**Re: Application by Cleve Hill Solar Park Ltd for an Order Granting Development Consent for the Cleve Hill Solar Park – Written Representation Submission**

Following the Planning Inspectorate's Rule 8 letter dated 7 June 2019, Kent County Council (KCC) submits its Written Representation.

Construction Traffic Routing
Figure 14.1

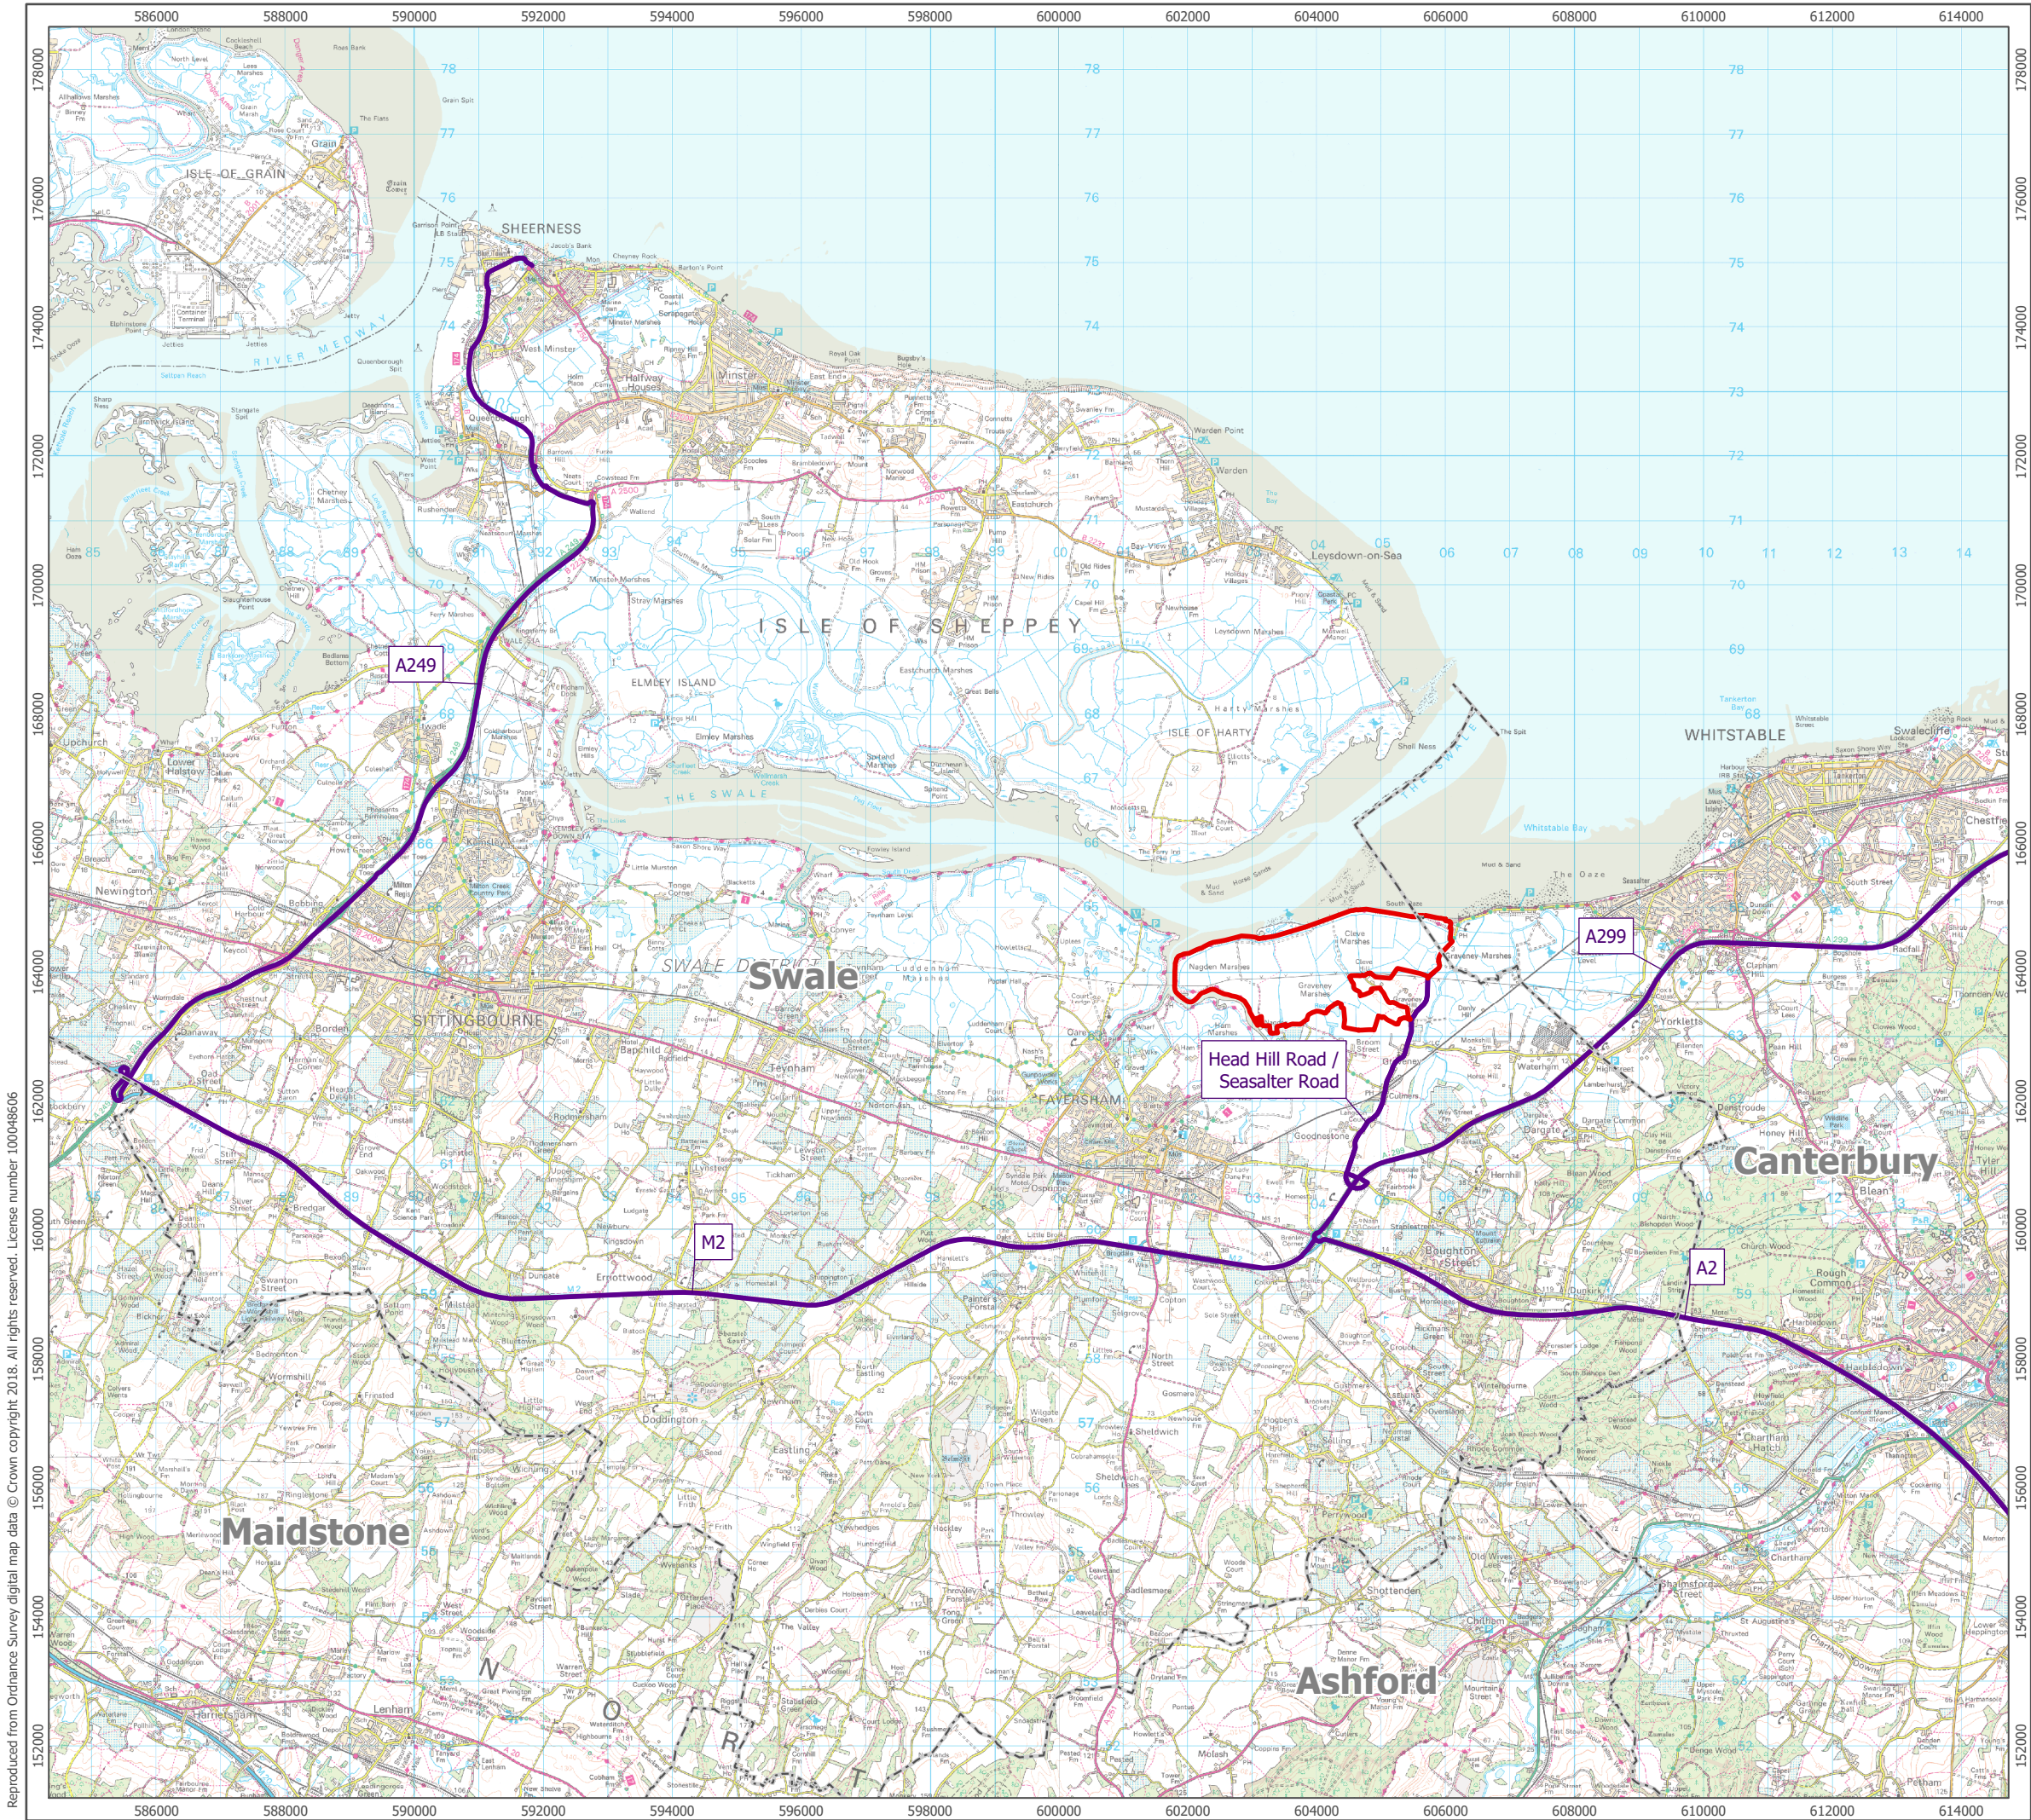
The route that will be taken by HGVs along Head Hill Road and Seasalter Road to access the development site is unrestricted and the traffic surveys indicate that these already handle regular volumes of HGV traffic flows. In the case of Head Hill Road, this currently experiences around 200 HGV movements per day, out of over 2,800 vehicle movements in total. This suggests that HGVs are a common feature expected along these roads and the white centre line marking, indicating a 5.5m carriageway width over the majority of the route, also points towards suitability. It is therefore considered that they are generally capable of accepting additional movements over a temporary period and these can be accommodated with appropriate mitigation.

KCC is content that the CTMP can be agreed prior to the development commencing and that this will control vehicle movements through the imposition of:

**Public Rights of Way
and NMU Survey Locations**
Figure 14.3

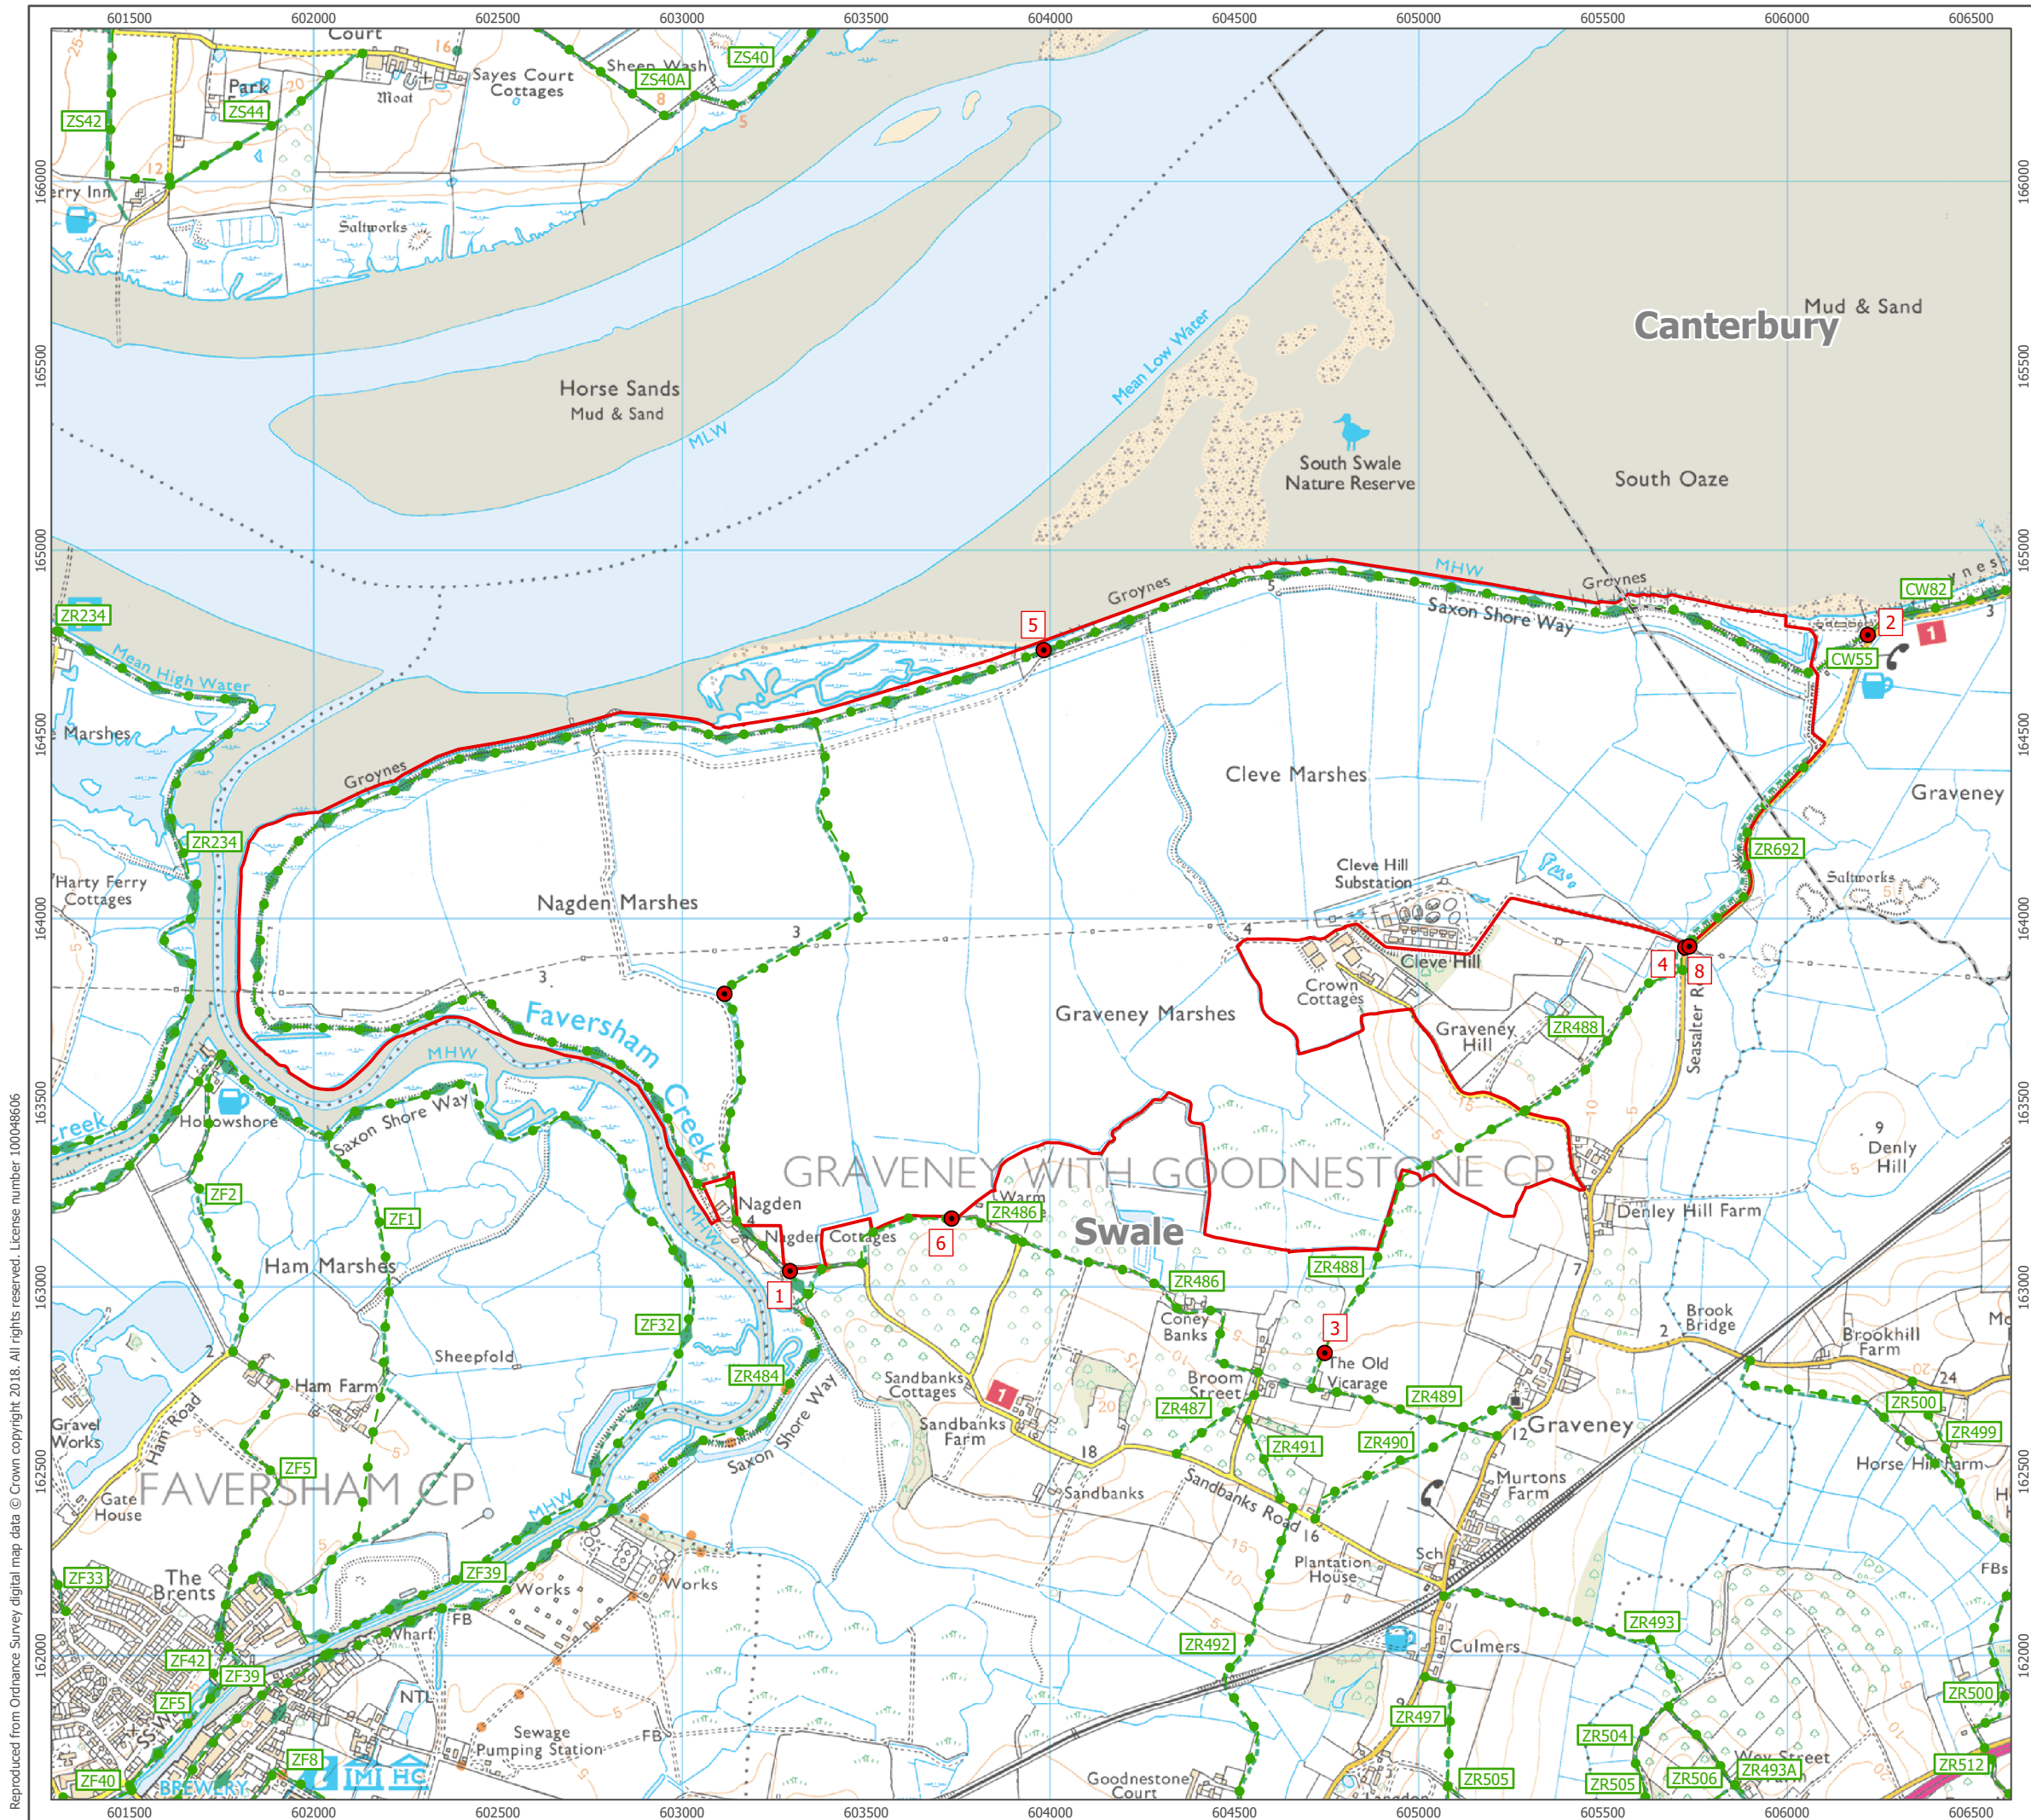
The County Council initially requested that electronic people counters were installed by the applicant at key gateway locations on the PRoW network, however the applicant commissioned 'Non-Motorised User' (NMU) video surveys. As the video surveys were only operating on four days, KCC disagrees with the applicant's view that data collected from their surveys is an accurate reflection of PRoW usage. Caution must therefore be taken when referring to the results of the NMU Survey (ES - Table 14.8), as the figures obtained during this limited study may not be truly reflective of actual path use.
